**ADC Planning Consultation
Response from the Historic Buildings Adviser**

Application Number	Y/89/13/L
Address	Hobbs Court, Bilsham Road, Yapton, BN18 0JY
Description	Application for Listed Building Consent for proposed conversion of outbuilding to single dwelling.
Case Officer	Simon Davis
Site Visit	Previous

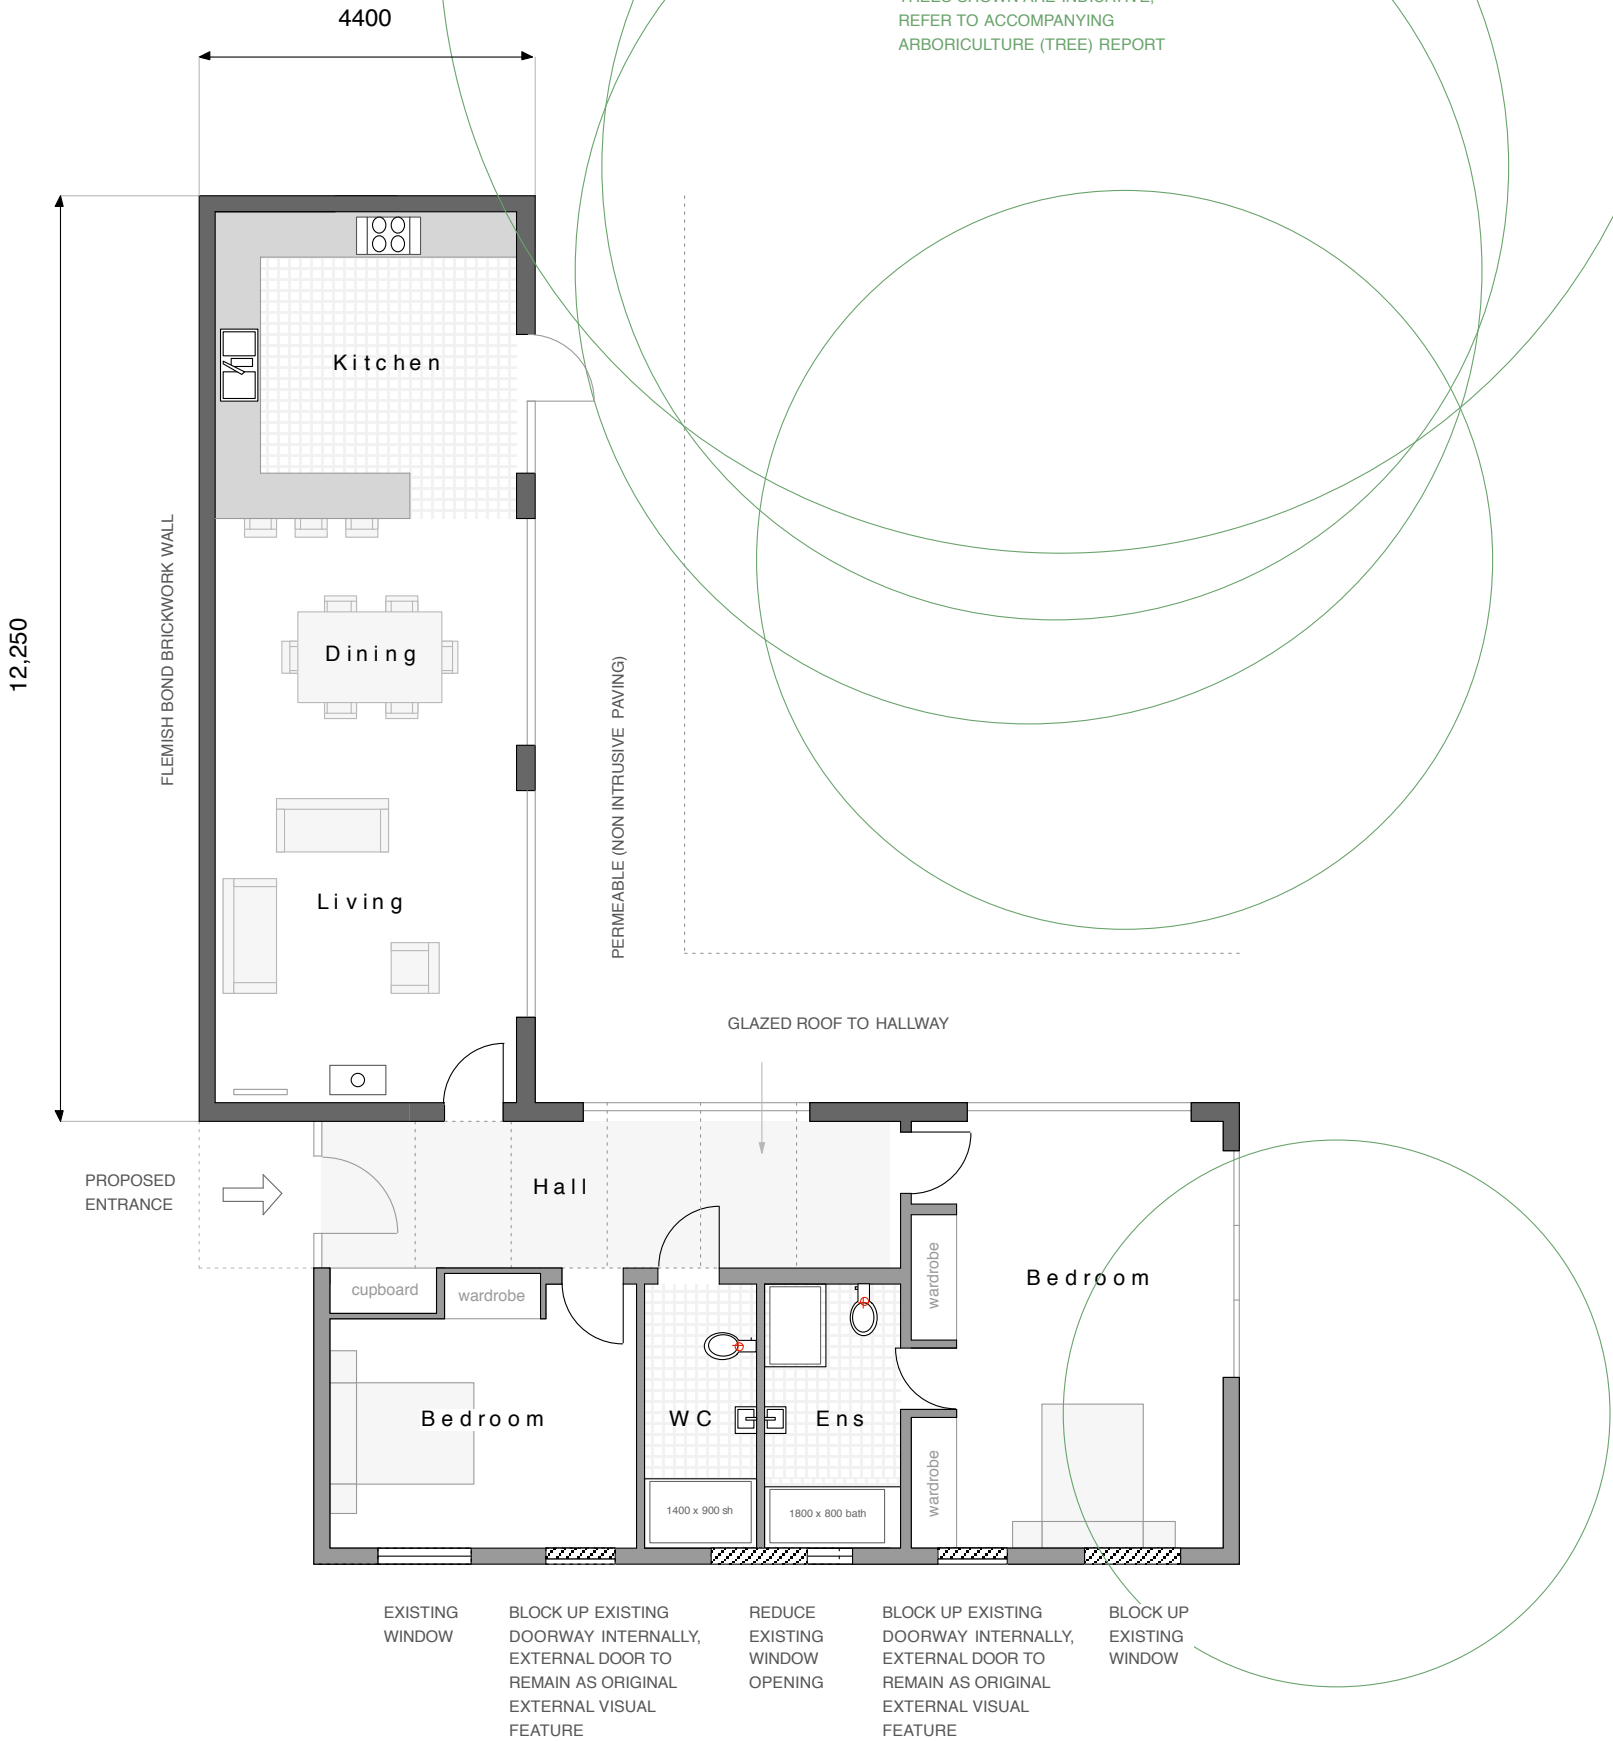
With respect to the design this should be improved. Whilst the elevations facing the barn are largely acceptable, the banks of large doors are not so convincing in this regard and need further amendment. Consideration should also be given to the treatment of the landscape/garden so that it does not appear overly domestic or suburban in character.
